# Charlotte Department of Transportation

## Memorandum

**Subject:** Rezoning Petition 08-119: Located on the southeast corner of South Mint Street and Lincoln Street

ILLUSTRATIVE SITE PLAN

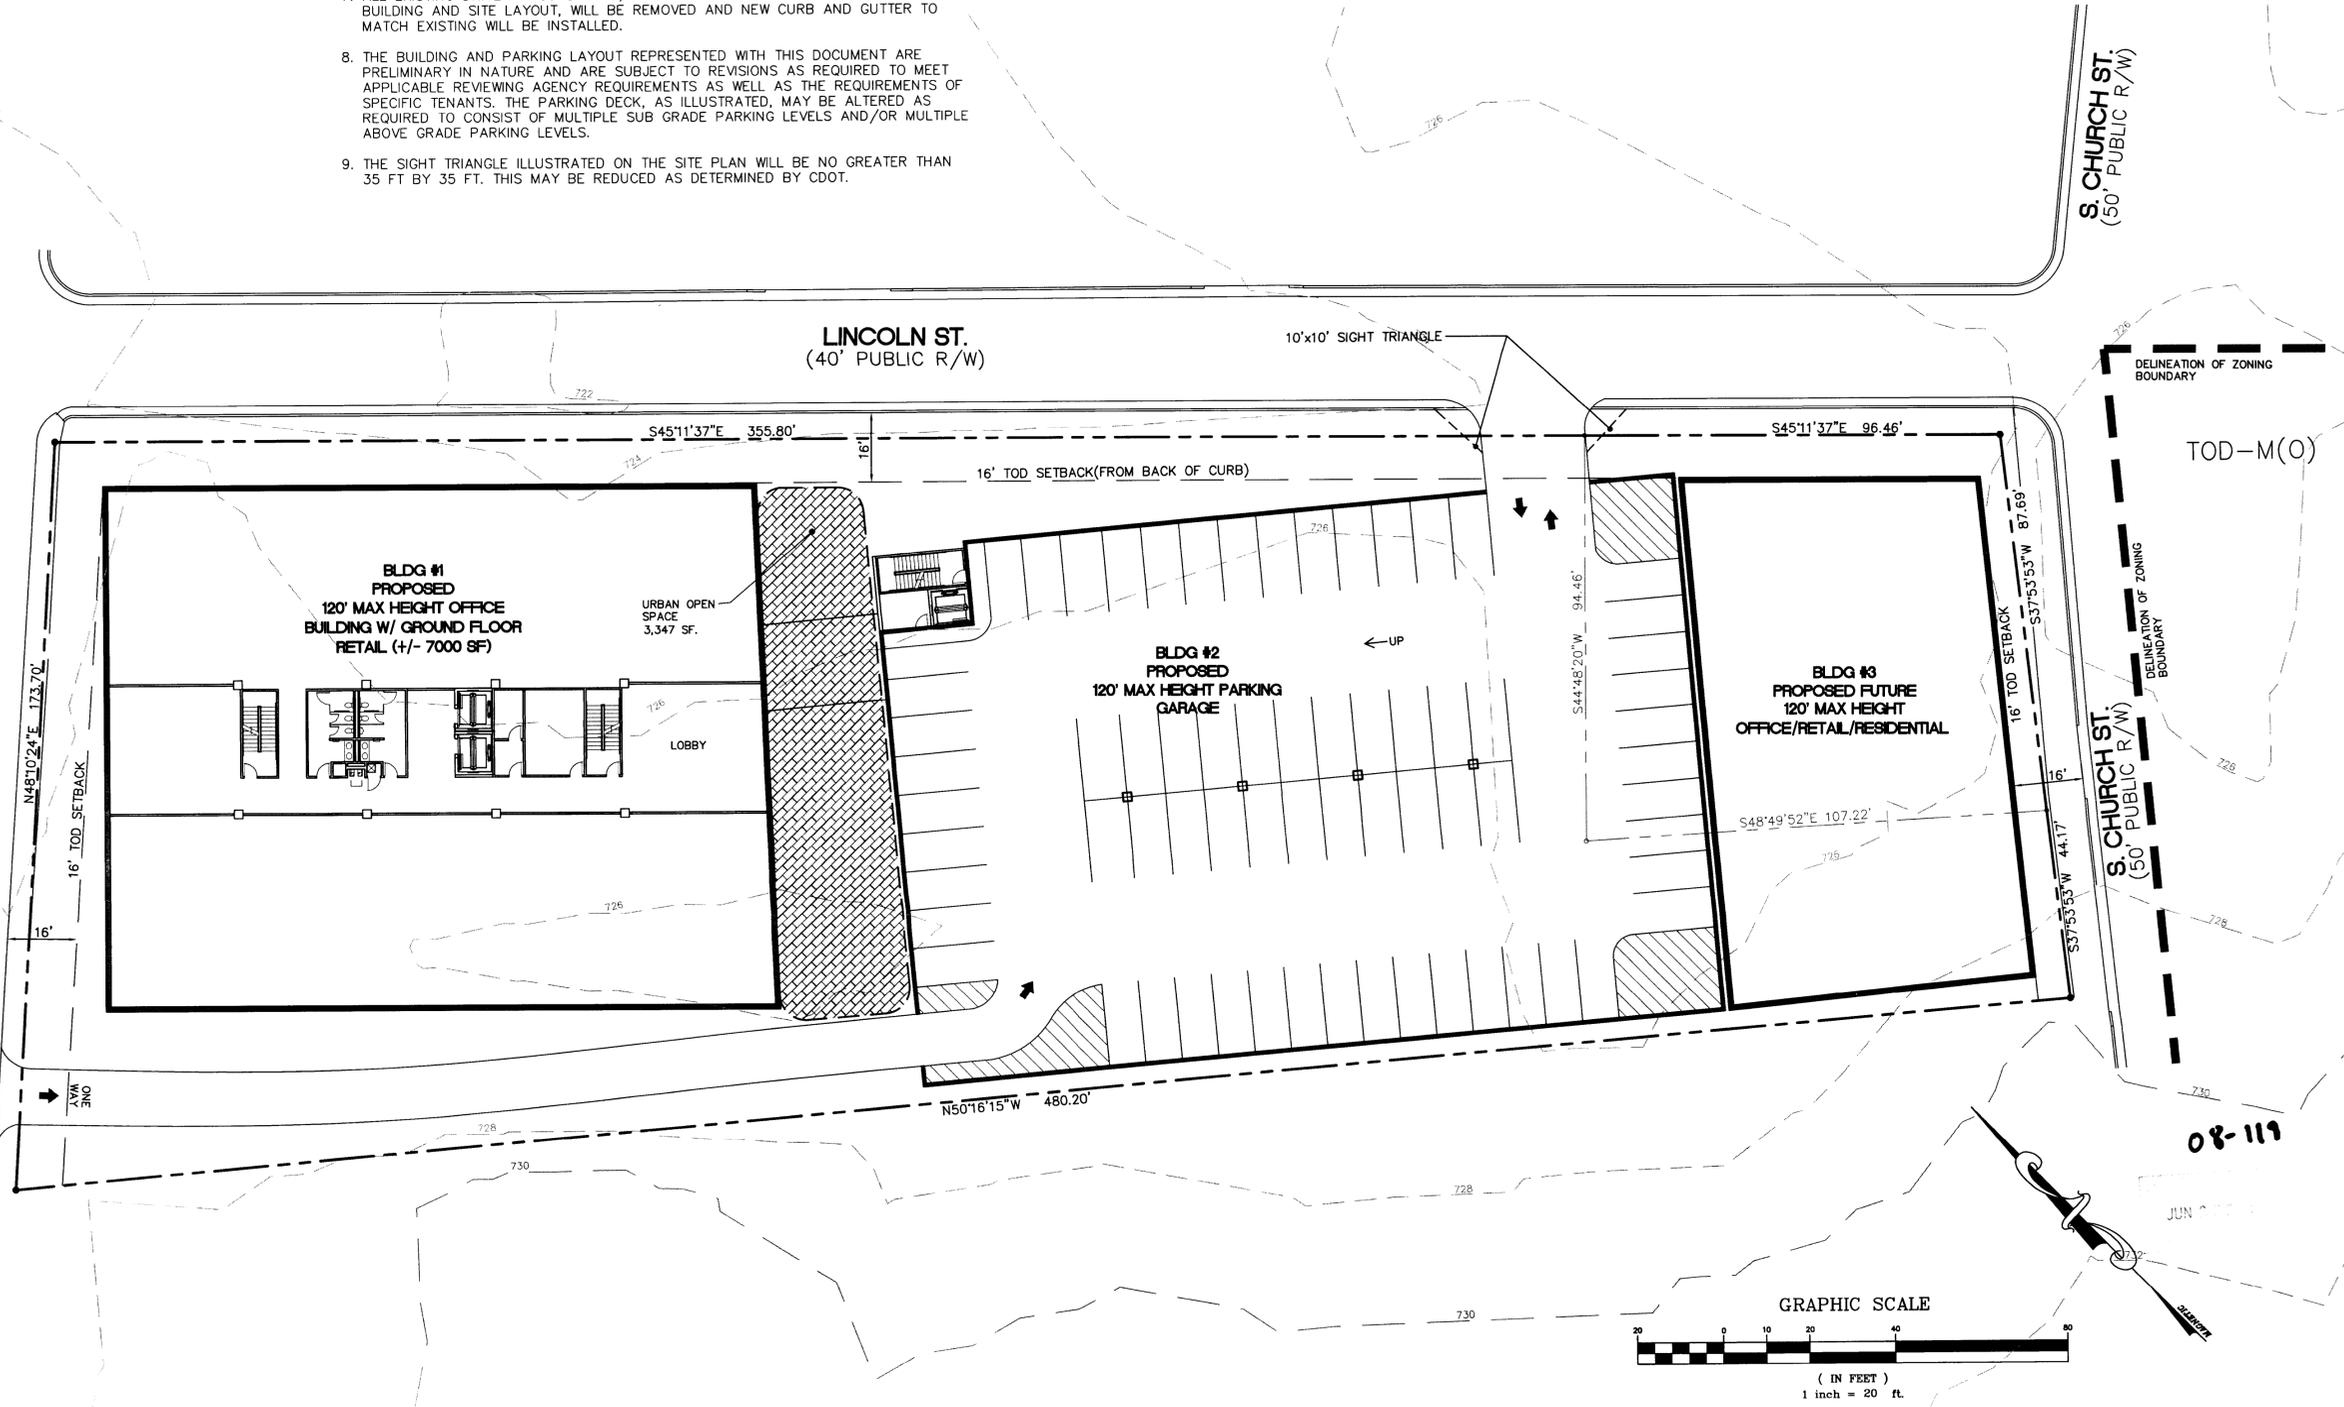
1. In conformance with the South End Transit Station Area Plan, South Mint Street has an adopted new cross-section with a 49' back-of-curb width. The TOD setback will be measured from the back of this future curb line.
2. The proposed zoning district requires 8' sidewalks and 8' planting strips along South Mint Street, as measured from the future curb line, as well as 8' sidewalks and 8' planting strips along Lincoln and South Church Streets. In order to facilitate the adopted future curb line of

South Mint Street, the developer may construct a wider planting strip in lieu of relocating the curb at this time. This would result in a 24' transitional setback, and has been discussed with the petitioner.

3. The location of any loading docks, service areas, and waste collection areas need to be shown on the site plan. Access designed for associated commercial vehicles also needs to be shown.

4. The typical dimensions for the parking spaces and aisles need to be provided for review. Additionally, the petitioner/developer should indicate the total number of proposed parking spaces and whether the parking deck is intended to be gate controlled. Reviewing this information at this time will assist in the design and later submittal of building/driveway permit plans for review.

5. Existing driveways on the opposite side of Lincoln and Mint Streets need to be shown on the site plan. Any proposed driveways need to be aligned directly opposite existing driveways to avoid turning movement/access conflicts.

6. This property needs to have cross access with adjacent uses to the south to provide inter-connectivity and access between uses that will not require unnecessary use of streets.

South Mint Street is a minor thoroughfare inside Route 4 requiring more than the minimum of 80 feet of right-of-way. The developer/petitioner should convey right-of-way in fee simple title to meet this requirement, measuring from the centerline of the roadway to the face of sidewalk and a 10-foot easement that includes the 8-foot sidewalk and 2-foot maintenance area..

Adequate sight triangles must be reserved at the existing/proposed street entrance(s) and corners. Two 10-foot x 10-foot sight triangles measured from the back of the sidewalk are required for the entrance(s) to meet requirements. All proposed trees, berms, walls, fences, and/or identification signs must not interfere with sight distance at the entrance(s). Such items should be identified on the site plan.
